**Ann Machado - RE: 118 Congress Street - Permit #2014-00464**

**From:** Ann Machado <[AMACHADO@portlandmaine.gov](mailto:AMACHADO@portlandmaine.gov)>  
**Date:** Tue, Mar 18, 2014 at 9:13 AM  
**Subject:** 118 Congress Street - Permit #2014-00464  
**To:** [sue@archetypepa.com](mailto:sue@archetypepa.com), [etheriault@e-tla.com](mailto:etheriault@e-tla.com)

I have completed my initial zoning review of the building permit. At this point I can't sign off because I need more information.

BUILDING ELEVATIONS
A2.01

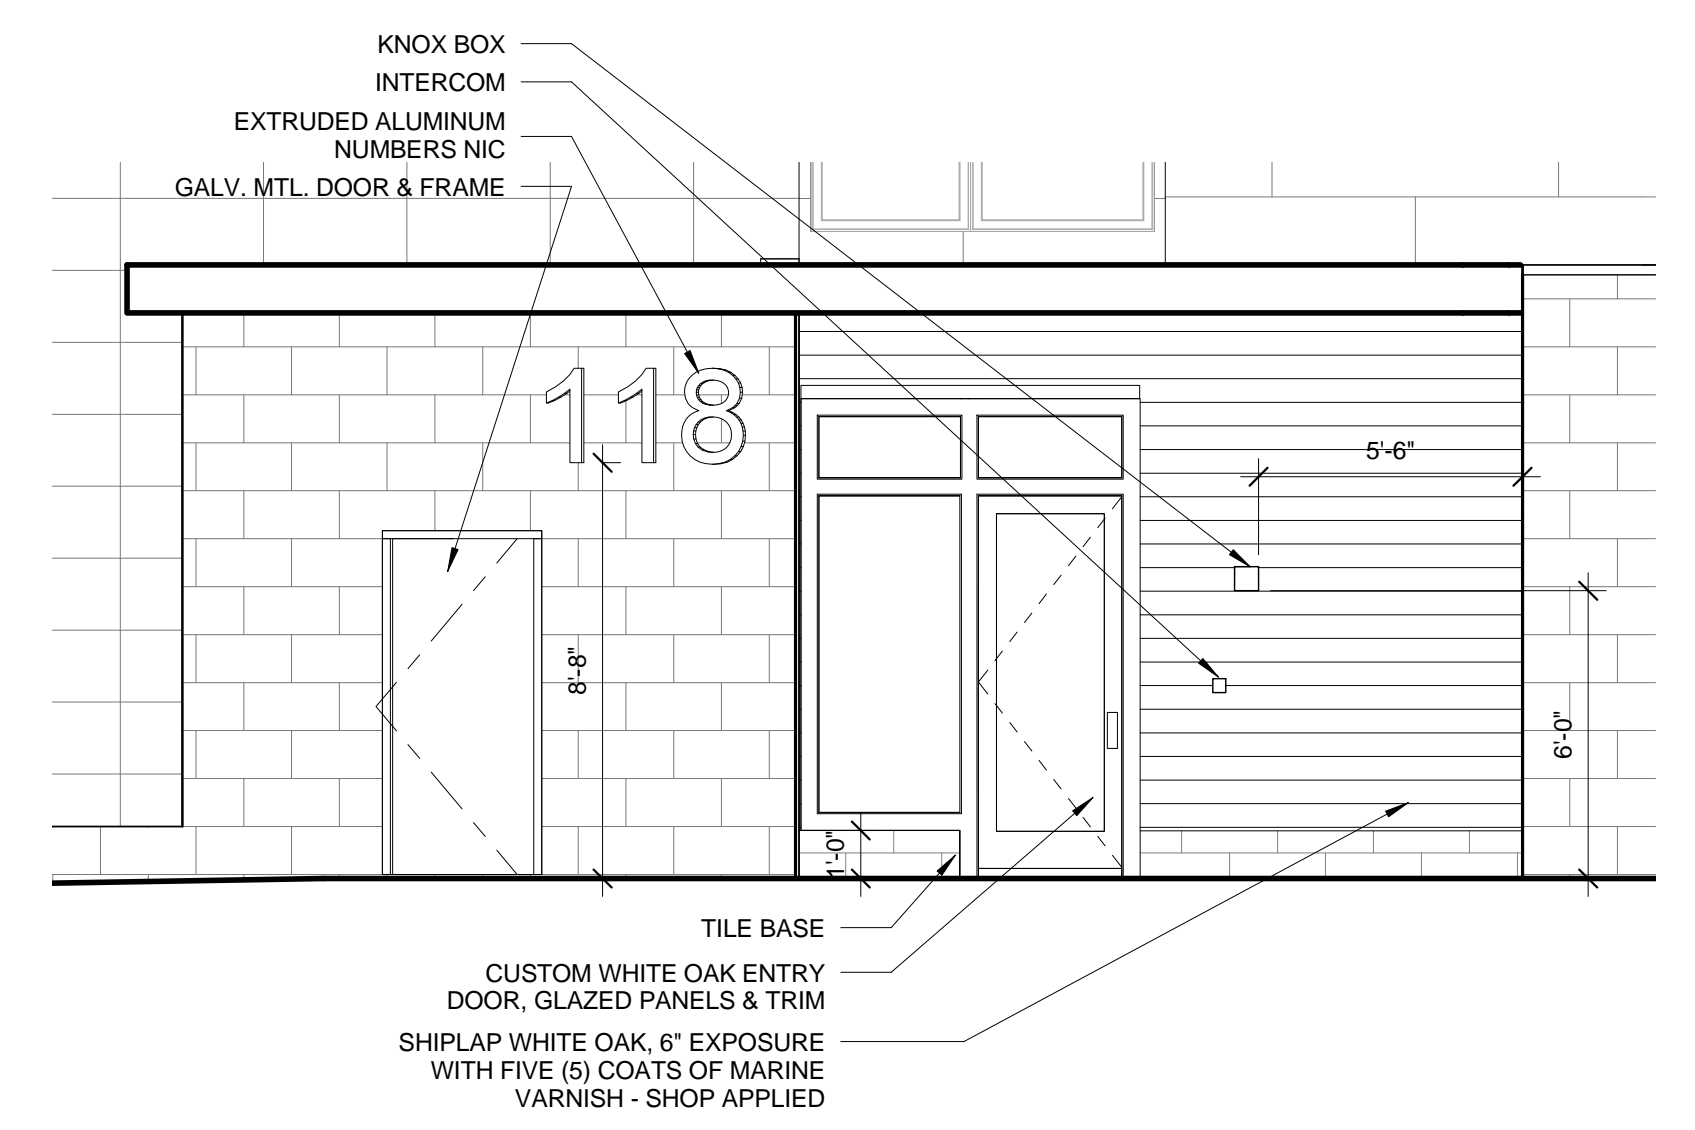
1. The building permit cannot be issued until a demolition permit is applied for and issued for the existing building.
2. The site plan (C1.2) does not show the overhangs.
3. The maximum building height is 50 feet. I need clarification on the average grade because it appears to slope down from the front of the lot to the rear. Also there appear to be sections of the roof that are higher than other sections.

The average grade of our building is taken by the four corner average grade. NW corner 147.45' + NE corner 147.15' + SE corner 147.25' + SW corner 145.00' = 588.5' / 4 = 146.71' (146'-8 1/2") average grade  
 The allowable building height, measured to the top of the roof truss is 146'-8 1/2" + 50' = 196'-8 1/2". Our building is designed not exceeding this dimension. The sections of the roof that appear higher than other sections as described in your previous email are only parapet walls. The main roof is all at one level.
